Response to Traffic Comment

TO: Ms. Jean Fraser, Planner
Development Review Program, City of Portland

DATE: January 9, 2013

RE: Response to TDM Comment
Applicant - J. B. Brown & Sons
Proposed Hotel, Restaurant, and Residences
321 Commercial Street, Portland, Maine
MMI #5002-01-4

SITE PLAN

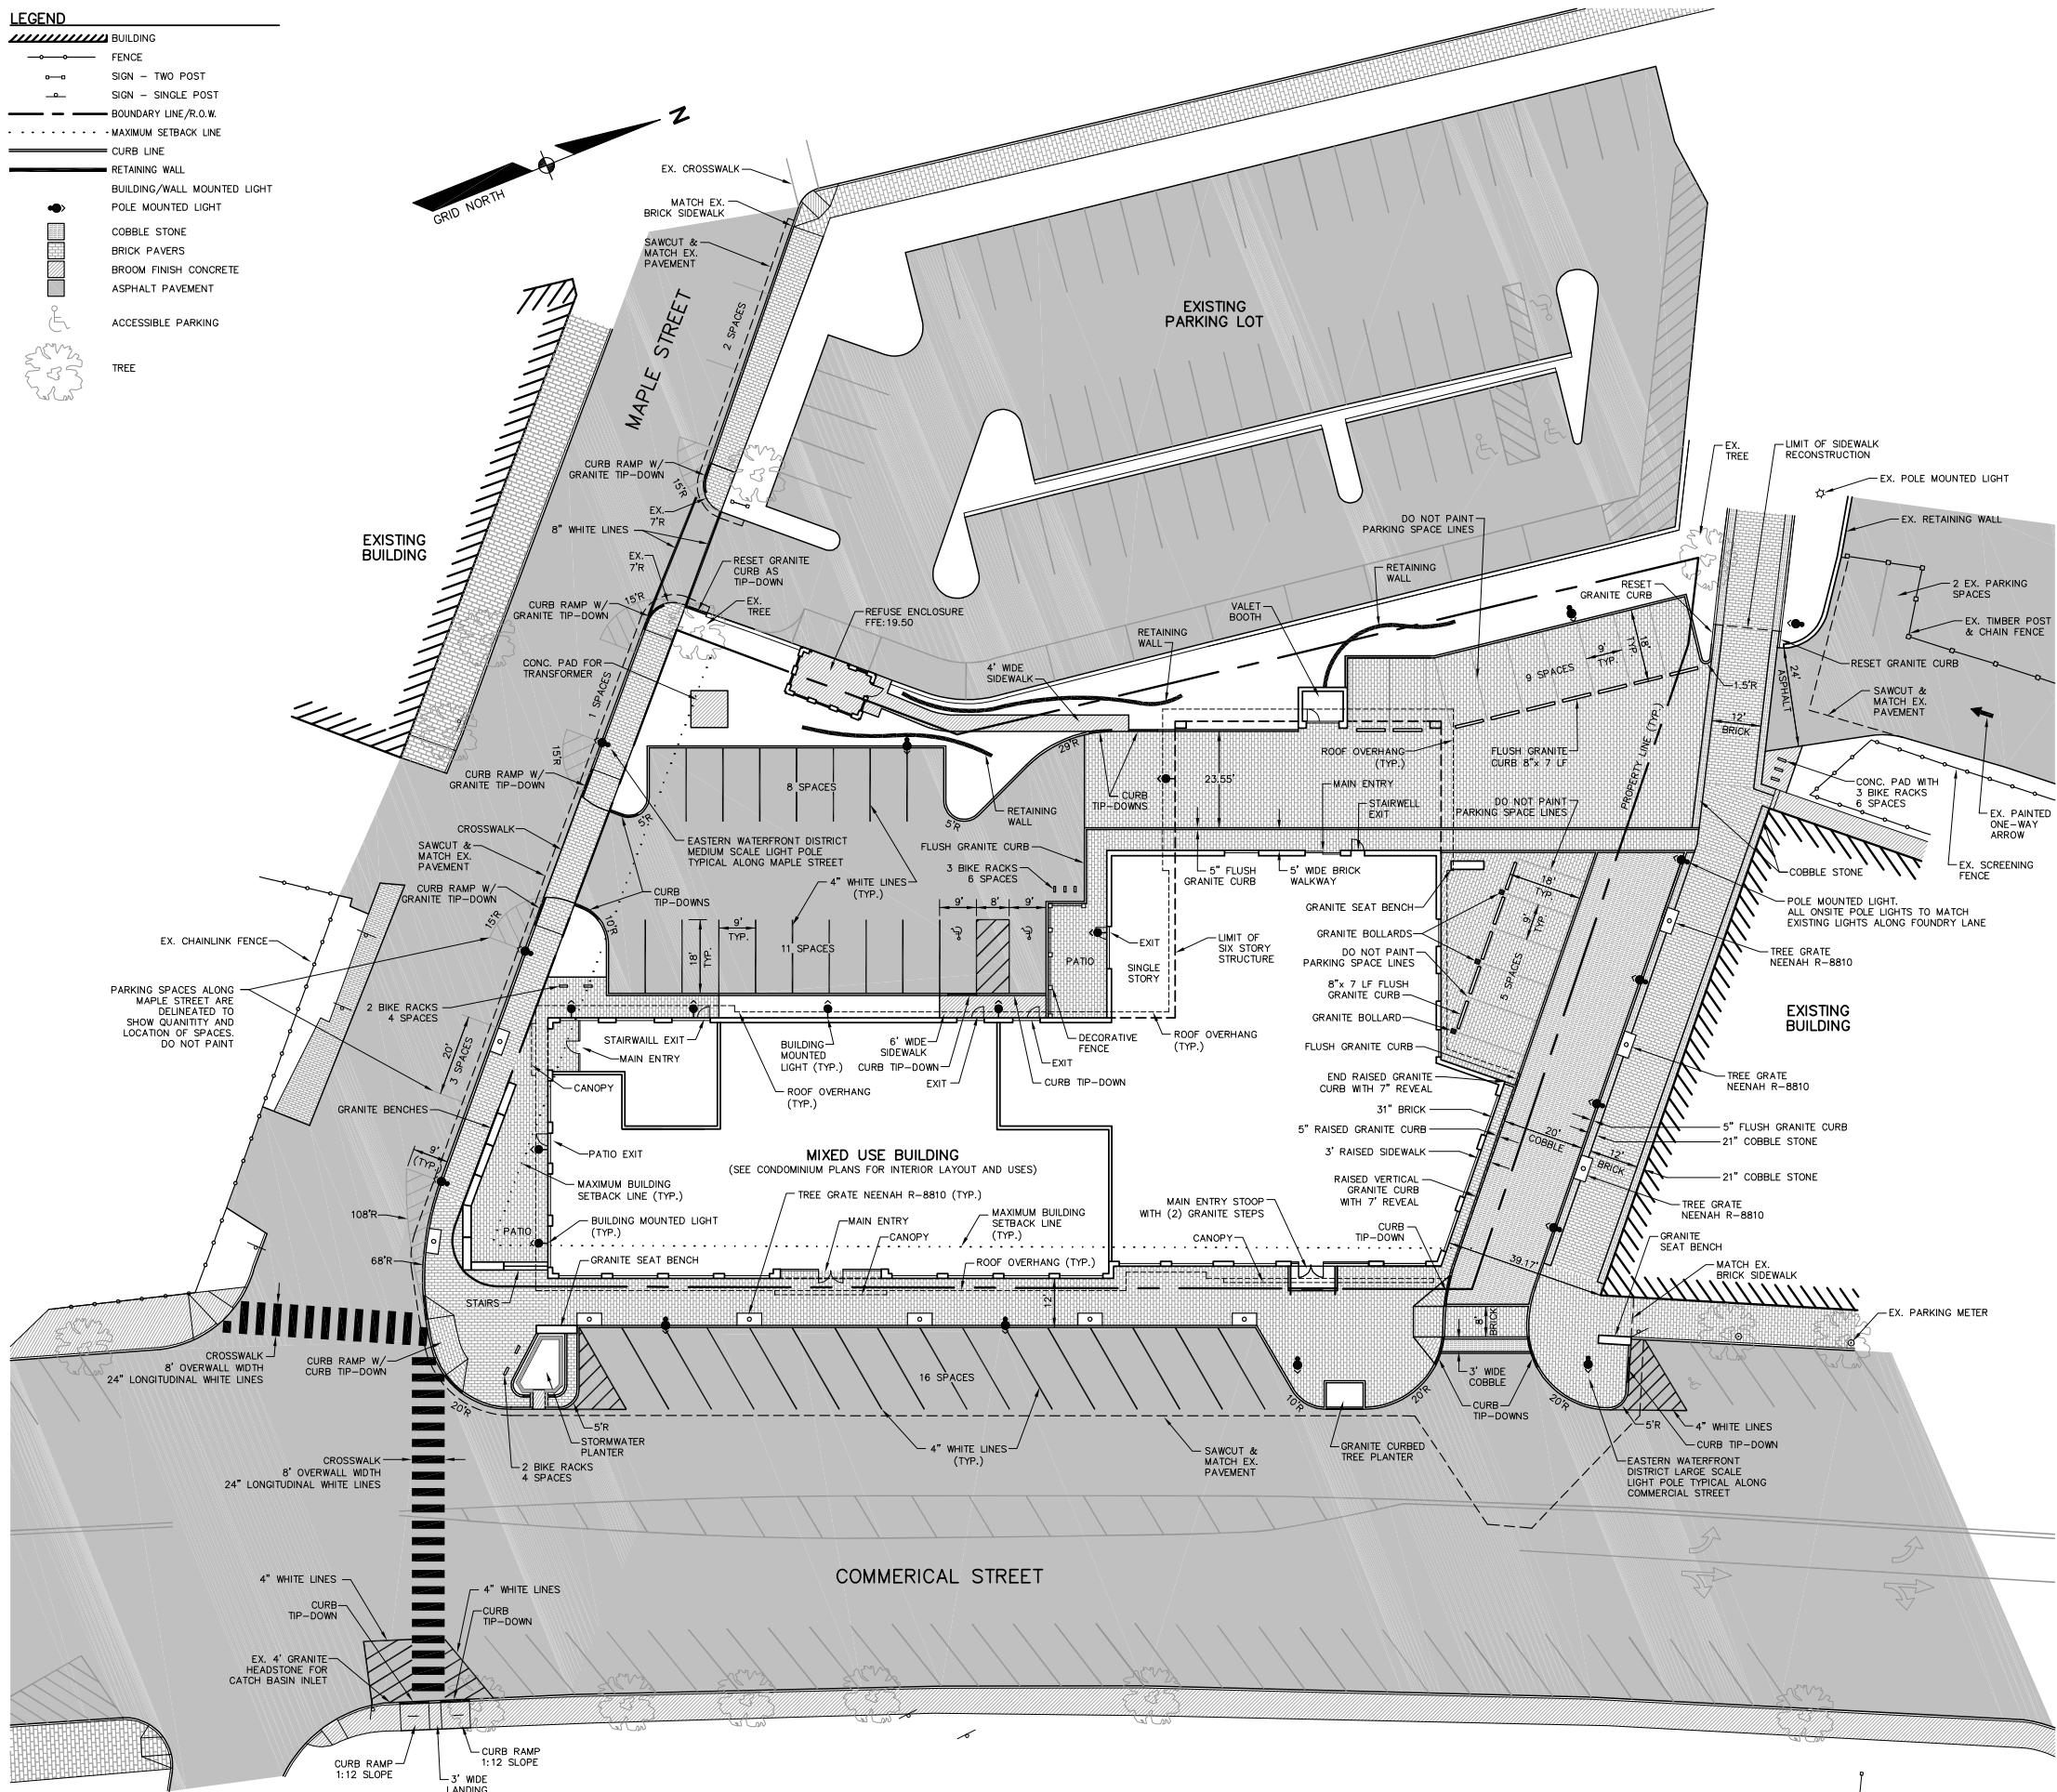
Comment: The TDM Plan offers many strategies for meeting the projects target traffic reduction goal, although many are noted to be the responsibility of the hotel in terms of implementation. I would suggest that the applicant identify the strategies that they are committed to be implemented when the project is completed, so that a fair assessment trip reductions strategies can take place.

- new crosswalks and ramps at the intersection of Maples St at Commercial Street
 - wider sidewalks and larger refuge areas along the developments Commercial St frontage

- the addition of granite benches along a portion of Maple St
 - continuation of the 12 ft brick walkway along the site's northerly boundary which will connect York St with Commercial St

- Extension of the Maple Street sidewalk connecting to York Street
 - The addition of aesthetic street lighting along the sites street frontage
5. Encourage Bicycle usage by providing enough bike racks for 26 bikes, no waiver will be requested. In addition employees of the hotel and restaurant will be given access to shower facilities.

Response: Listed below are the TDM actions and strategies that the applicant is committed to implementing.
